From: Laura Gibbons
Sent: 25 January 2019 11:33
To: Simon Davis <Simon.Davis@arun.gov.uk>
Subject: RE: Y/92/18/DOC- Further Drainage Supporting Info

Typical Road and Swale Section
Scale 1 : 25 at A1

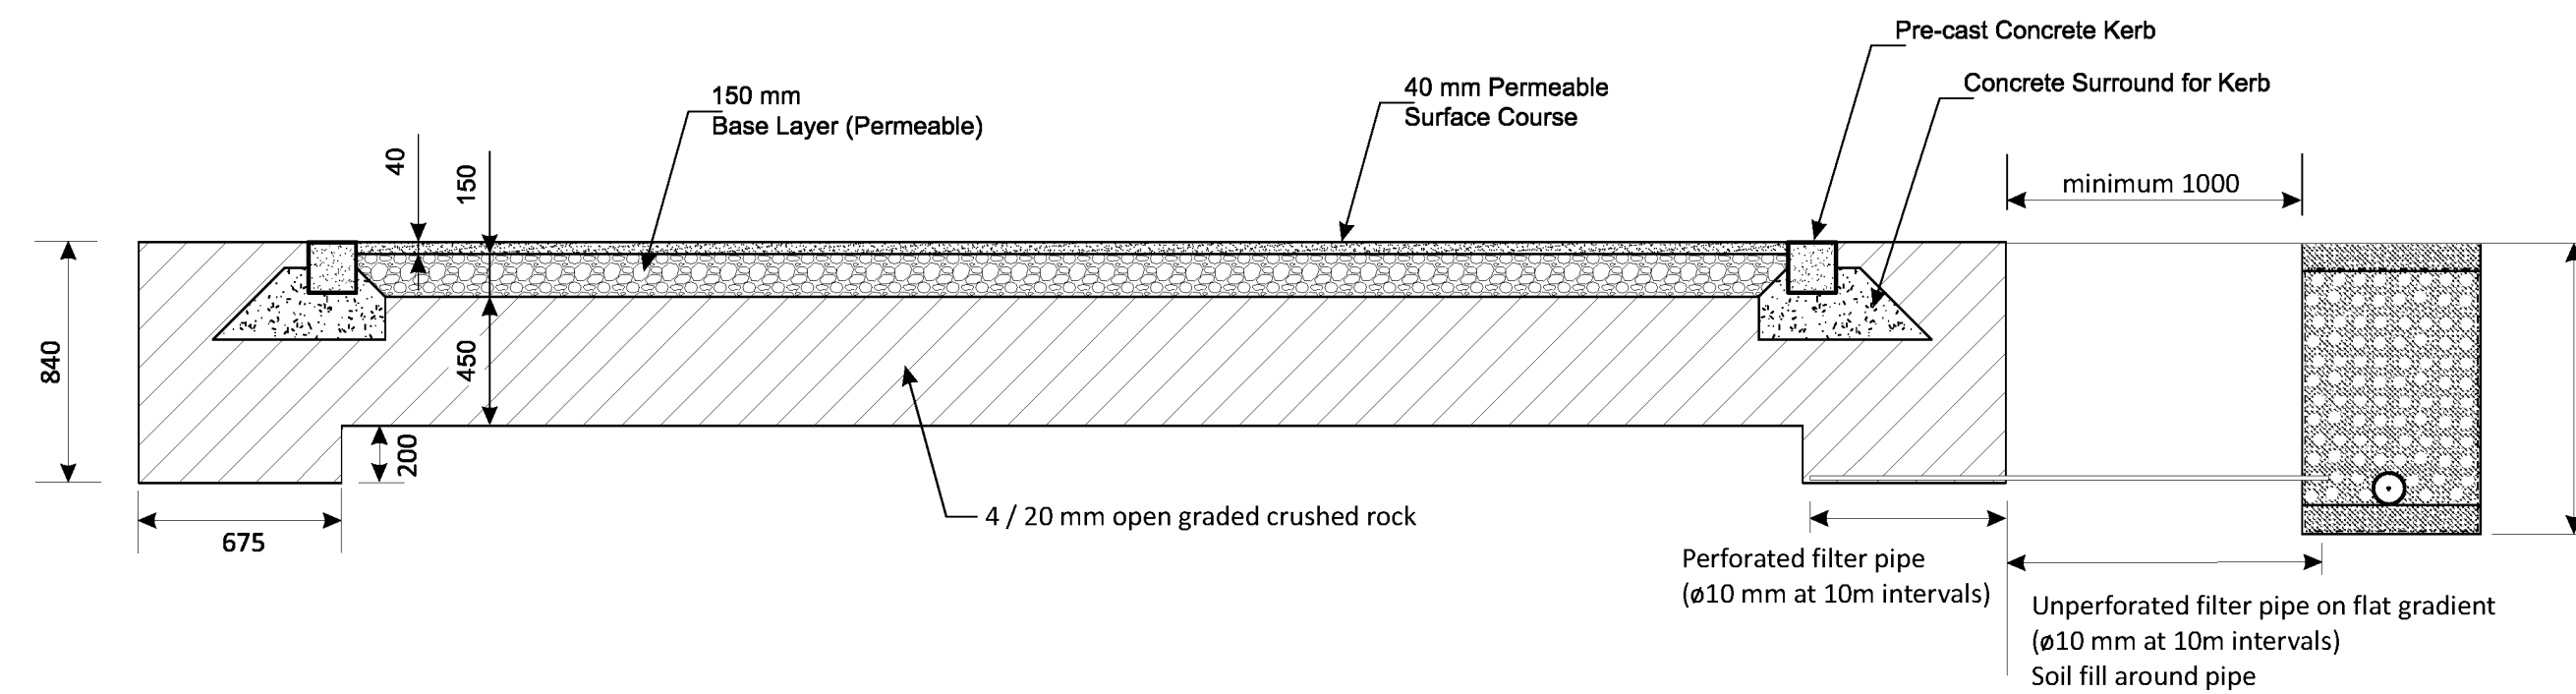
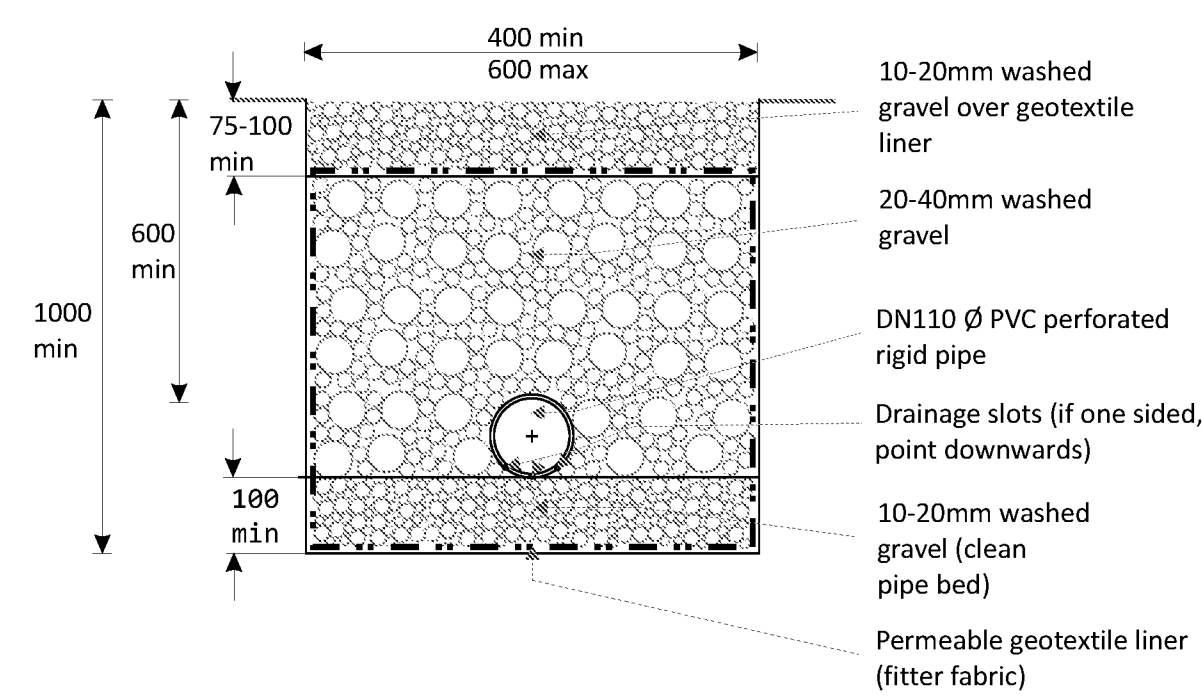
9. The permeable paving construction details need to show permeable membranes are being provided. No details of the permeable surface course have been provided, and need to be.

10. Please detail what material will be used for the 150mm permeable base layer.
11. Sufficient construction detail drawings haven't been provided.
12. Sufficient details on layout plans have not been provided.

Eastern Bank of Reservoir

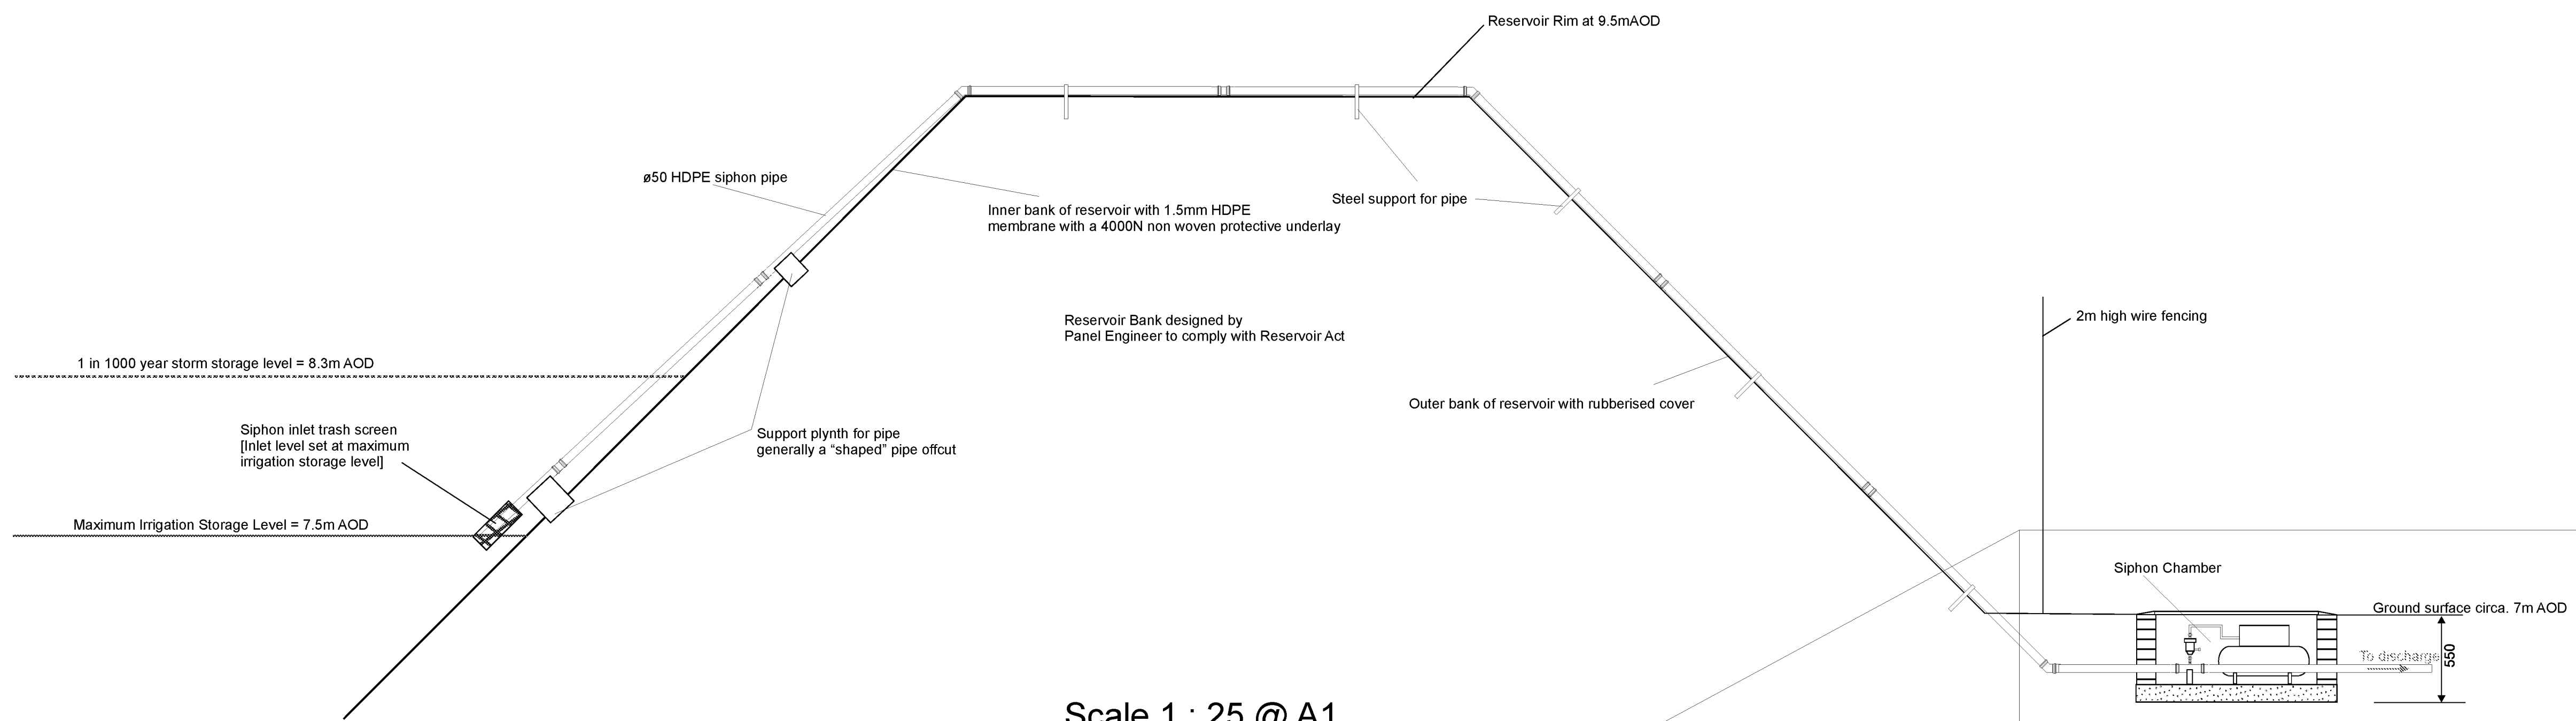
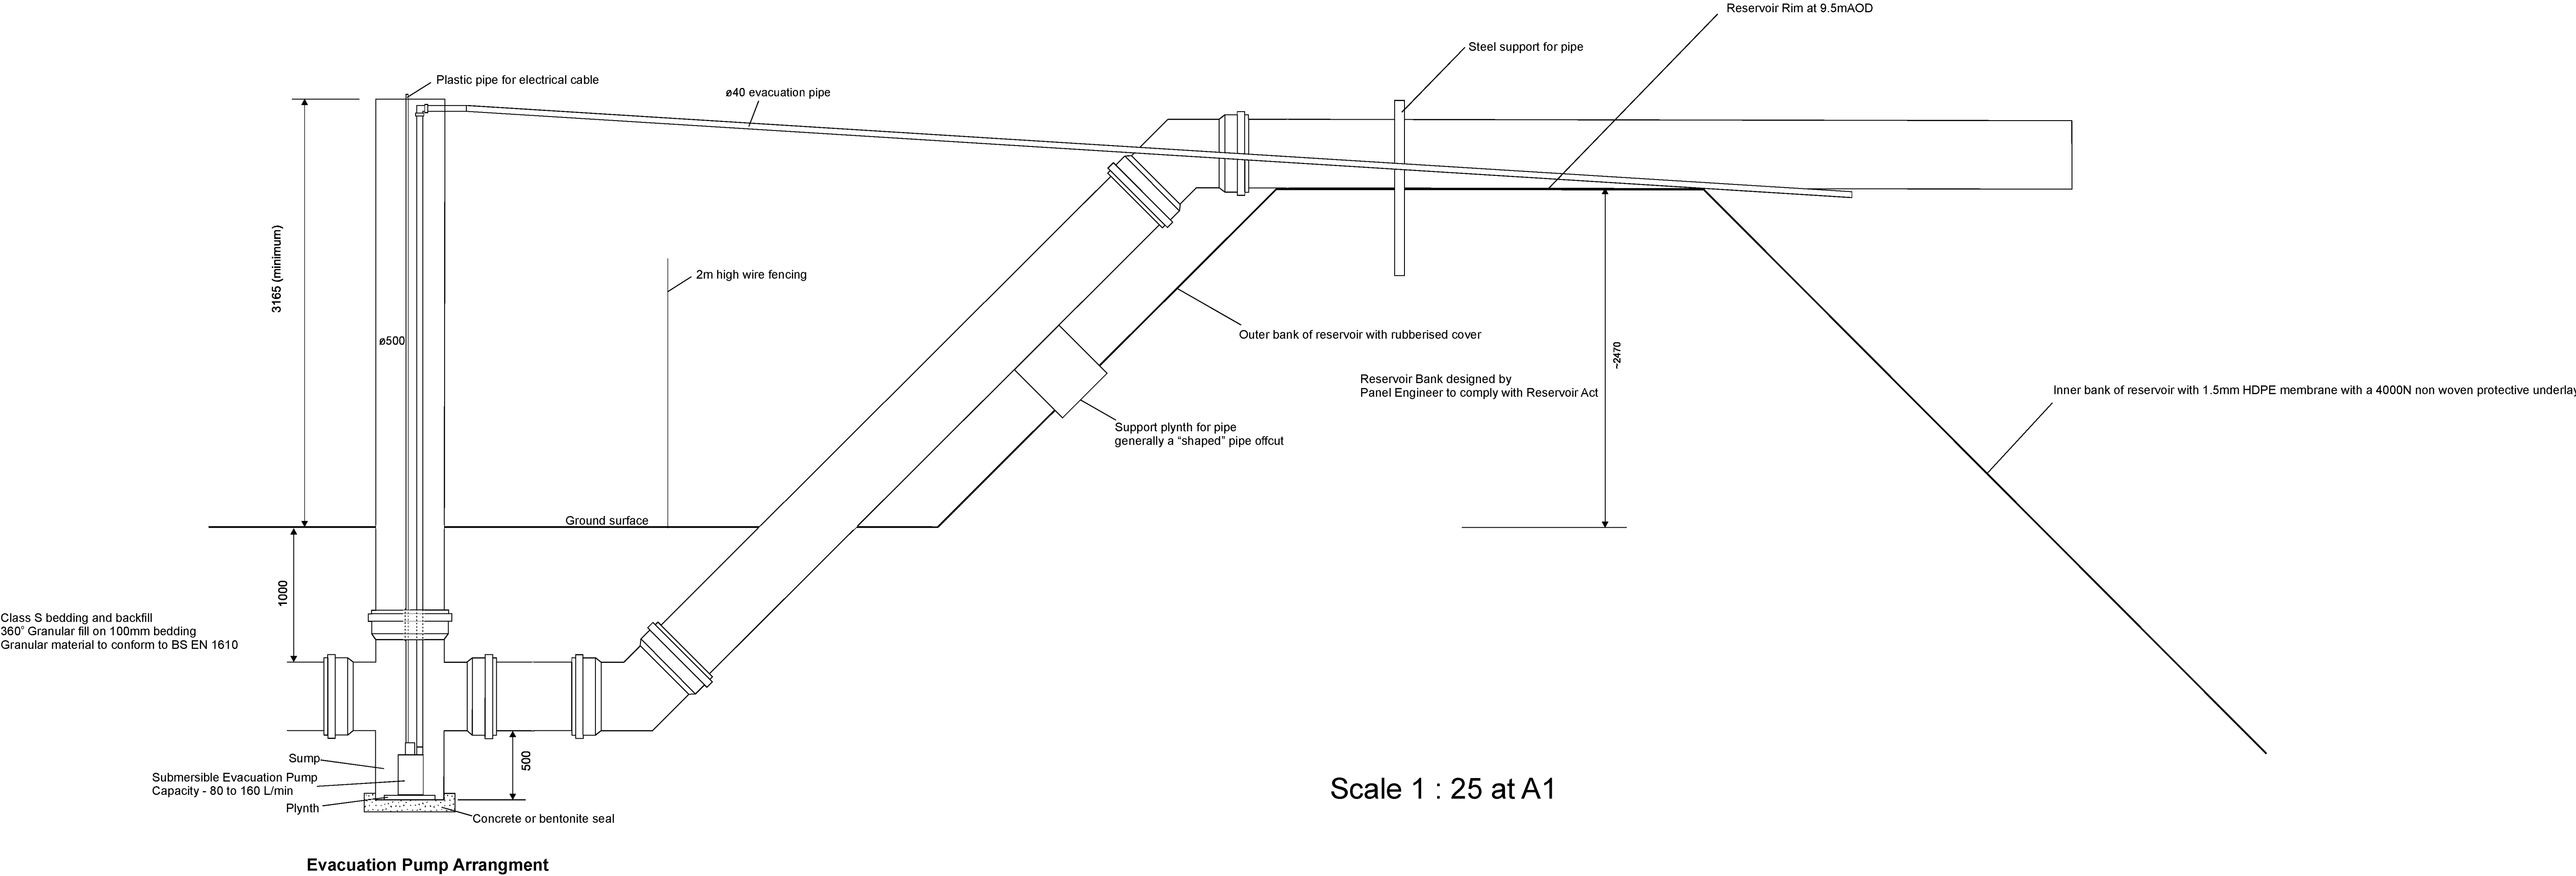
7. Full details of the attenuation basin will therefore need to be provided.
8. No dimensions have been provided on the attenuation basin and siphon drawings. This needs to be detailed.

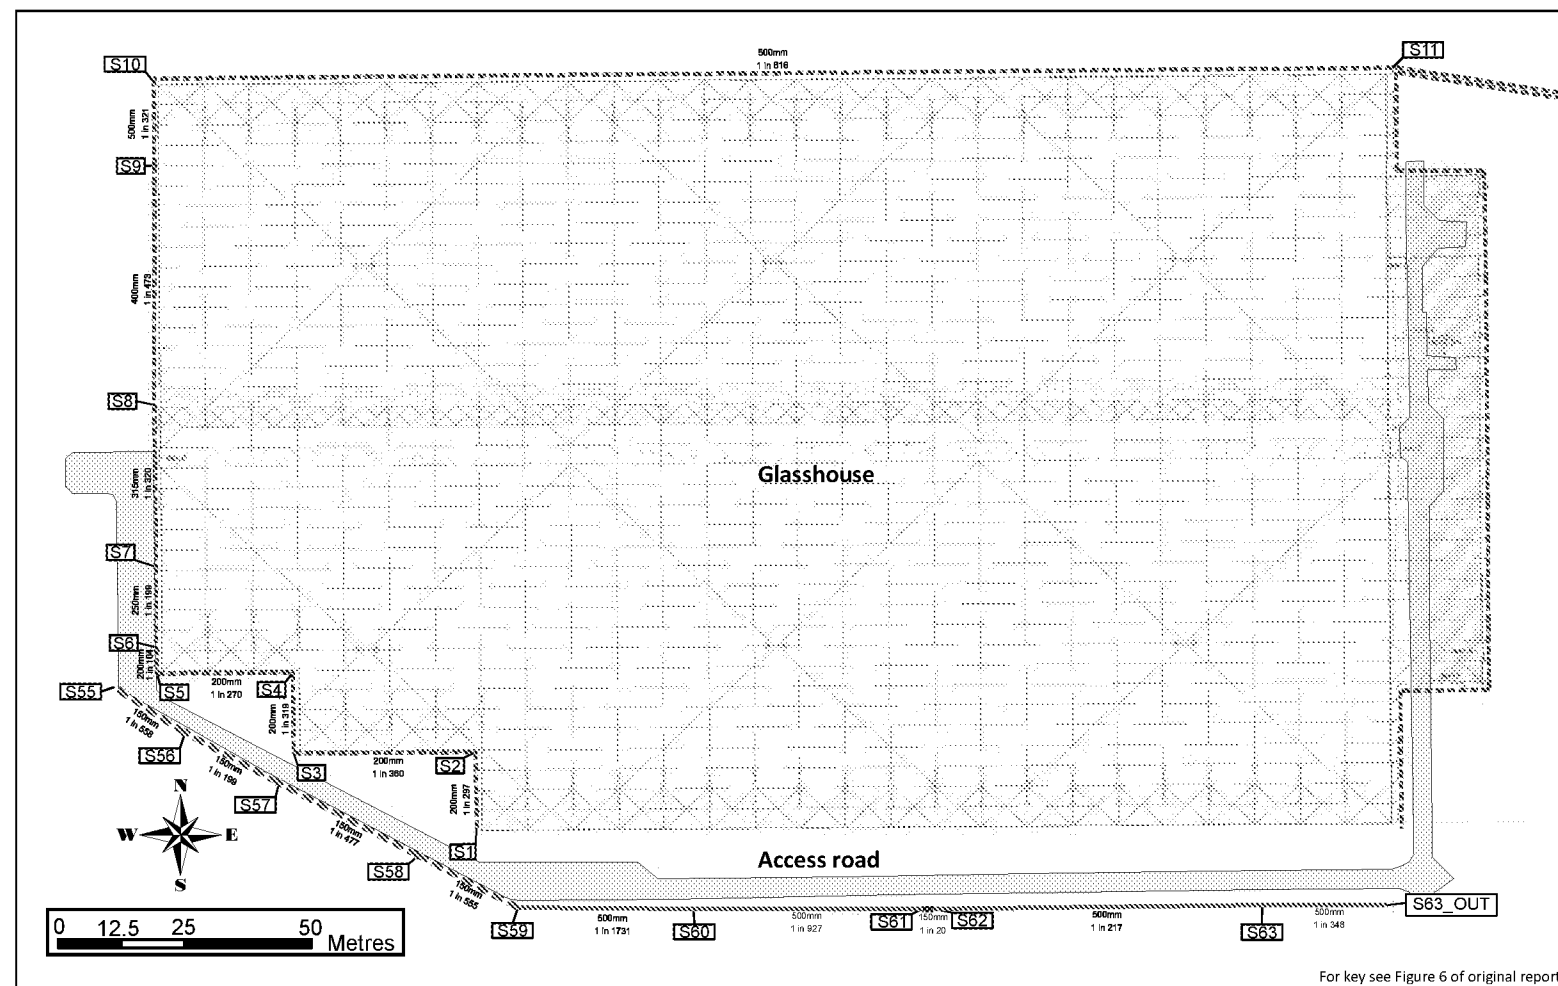
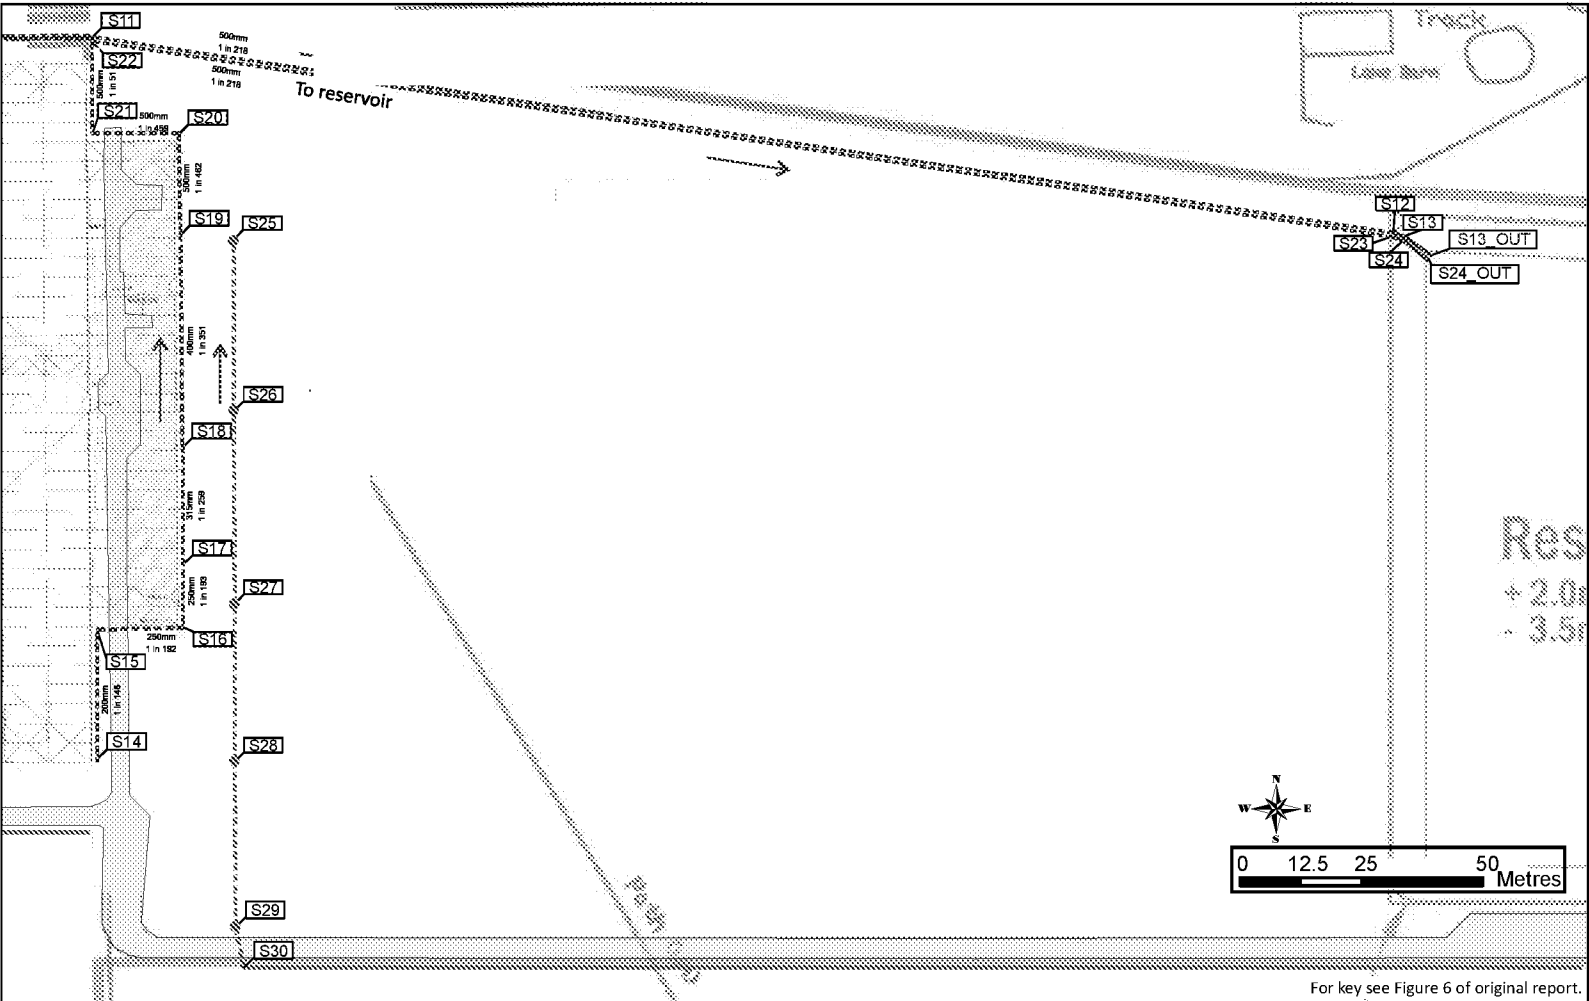
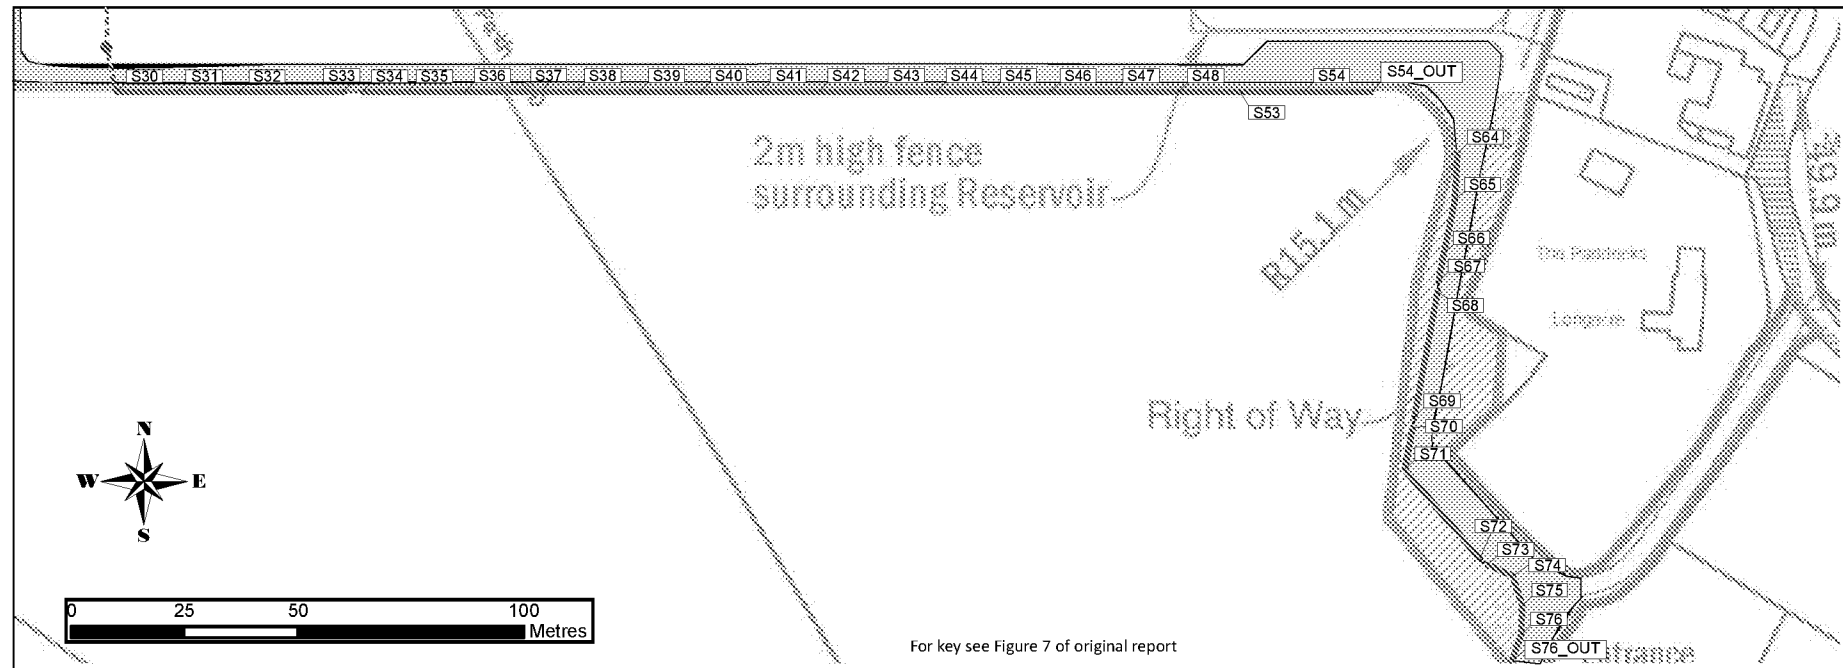
2. Calculations regarding the permeable paving and swale will need to be submitted based on these results.
3. The swale is currently modelled with a free outflow point, this isn't the case in reality. Calculations need to be based on reality.
